**Consultation Response from KC,
Lead Local Flood Authority**
2021/91871 Land adj, High Street and Challenge Way, Hanging Heaton, Batley
Erection of residential development including access and associated infrastructure
**Date Responded:
01/06/2021**
**Responding Officer:
Martin Stephenson**
**Responding Ref:
0**
Detailed Consultation Response

SCALE WHEN PLOTTED AT A1		DRAWING STATUS	
1:500		PRELIMINARY	
DRAWN	CHECKED	DATE	DRAWING NUMBER
CH	PR	11.11.20	45467/001
			REV
			D

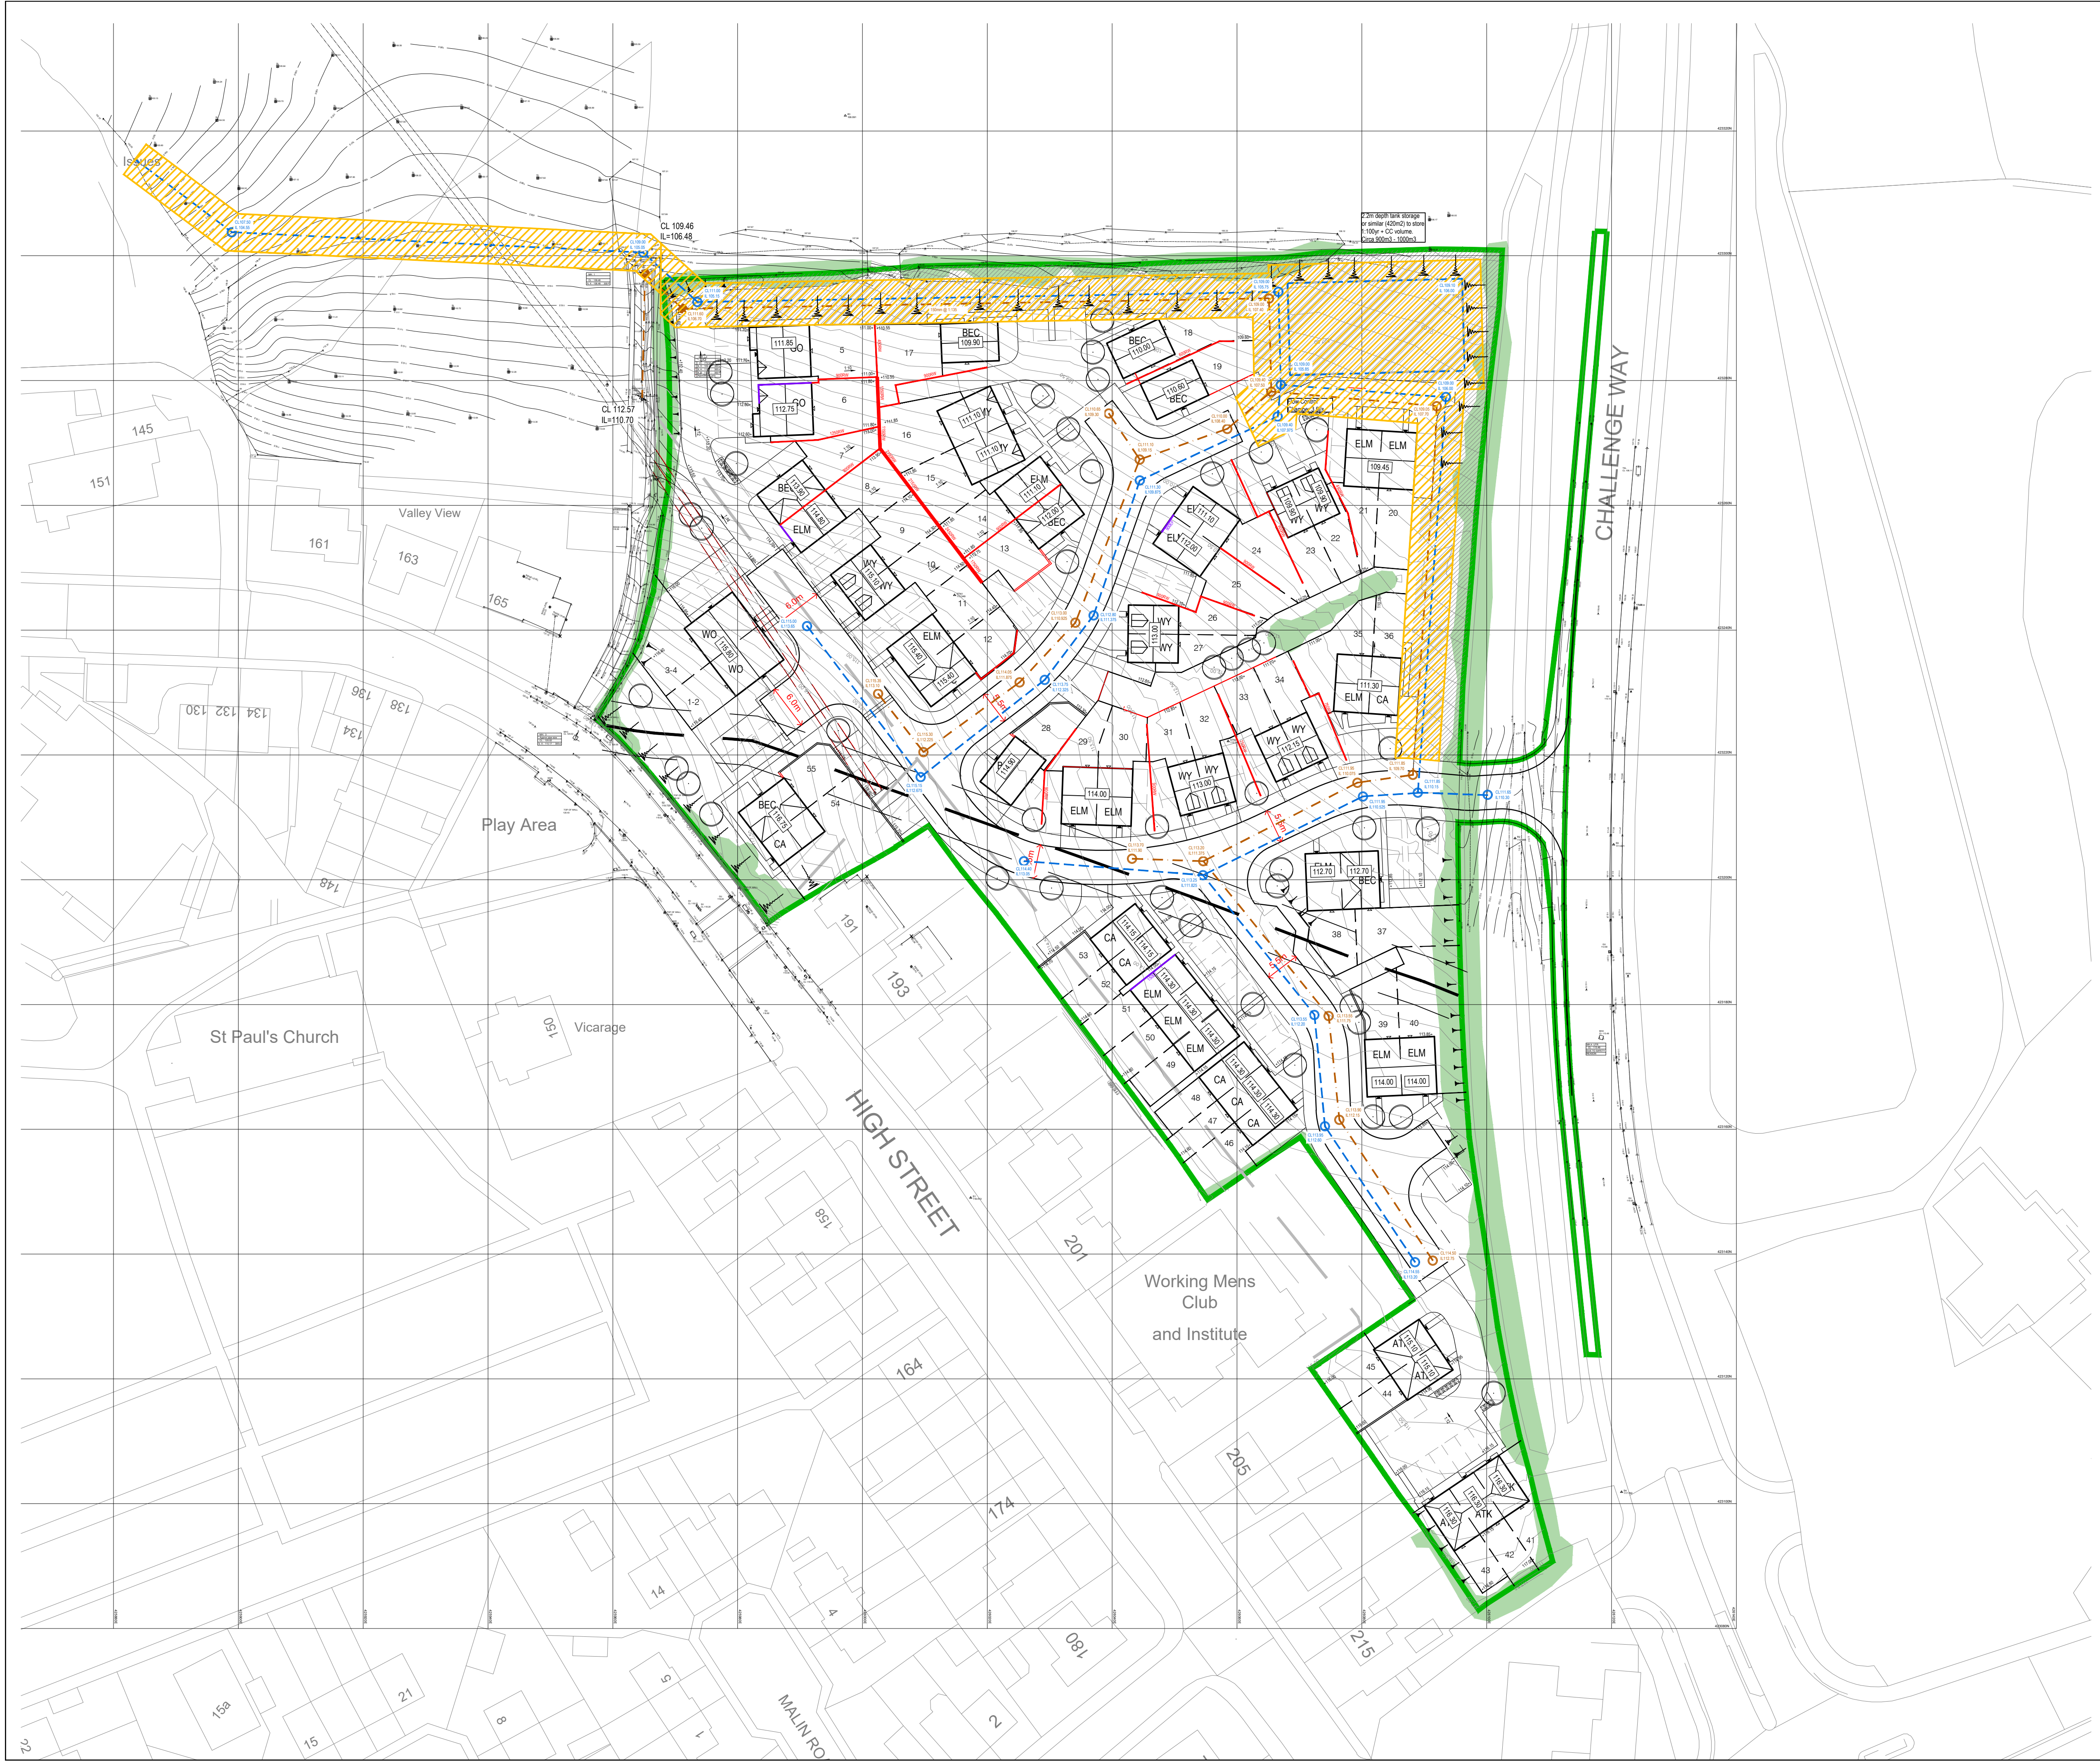
The submitted drainage drawing (E&P ref: 45467/001 Rev D dated 11/11/20) does not indicate how the tank is connected to the surface water drainage system, however it is assumed that the outlet is to the chamber adjacent to the south-west corner of the tank. The inlet MH should be of the silt trap/catch pit type to reduce the risk of siltation within the tank.
